Indaver Rivenhall IWMF DCO

Applicant Comments on Deadline 1 Submissions

Document Reference: EN0101038/APP/9.2.2

21 May 2024

Figure 7.1: Grid Displacement Factors

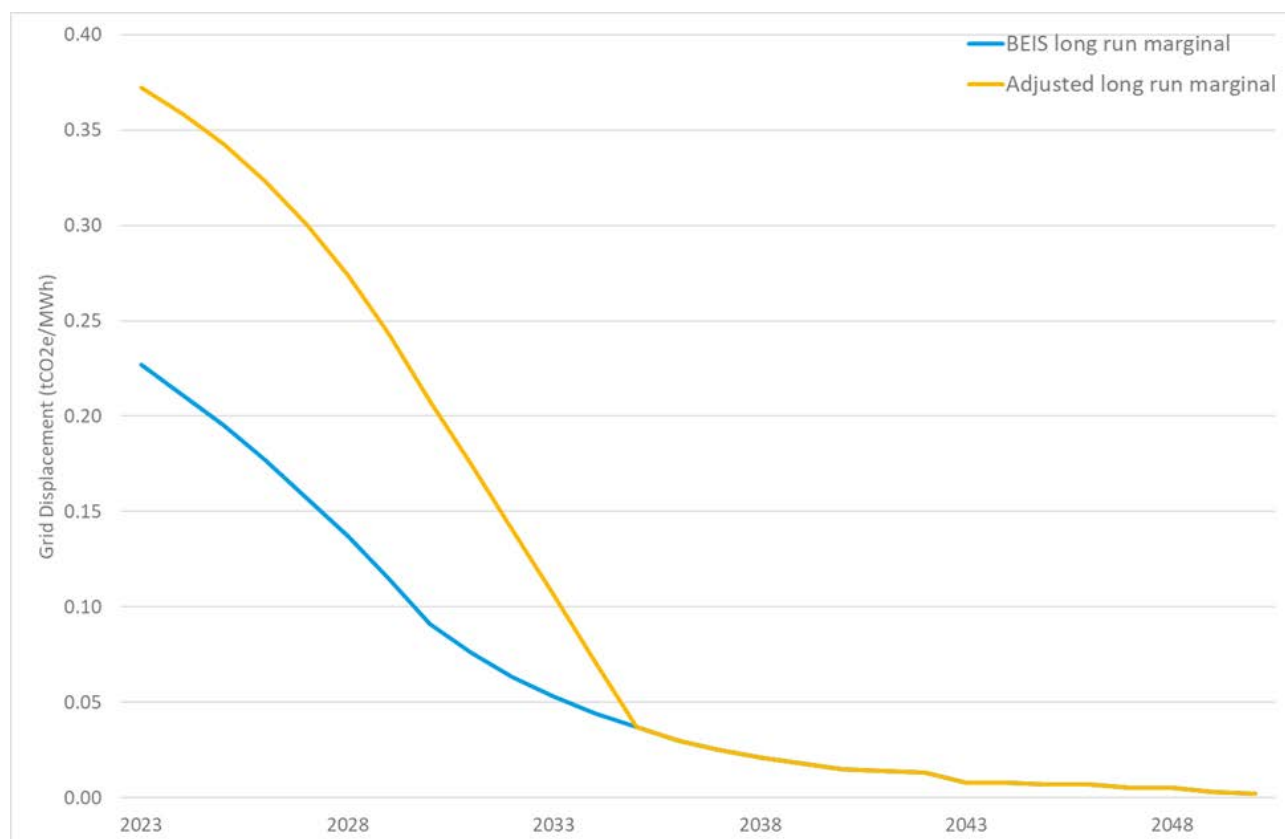
BDC 8.41-8.45	BDC suggests that assuming that the additional electricity produced by the Proposed Development would displace power generated by a gas-fired power station is incorrect. This is because BDC considers that the 2014 Guidance is out-of-date.	The key footnote in the 2014 Guidance, as referenced in paragraph 7.4.9 of the ES, Vol. 1, Chapter 7 [APP-032] , has been confirmed to be correct in a number of recent SoS decisions.
BDC 8.45	BDC states that “the Environment Statement has not commented on the efficiency of the plant and has made an assumption that ALL of the carbon dioxide can be offset by taking the footnote comparator out of context from the entire report.”	<p>All of these statements are incorrect. The ES makes it clear that the plant will generate more electricity from the same amount of waste, so its efficiency will improve with the Proposed Development.</p> <p>It is not assumed that all of the carbon dioxide can be offset – it is assumed that all of the additional electricity can displace other sources of electricity.</p> <p>The footnote has not been taken out of context. The footnote confirms that the marginal source of electricity would be displaced. This is CCGT in the opening year. However, as explained in paragraph 7.6.6 of the ES, Vol. 1, Chapter 7</p>

[APP-032] the lifetime benefits have been evaluated on the assumption that the marginal source would be decarbonised.
--	--	---
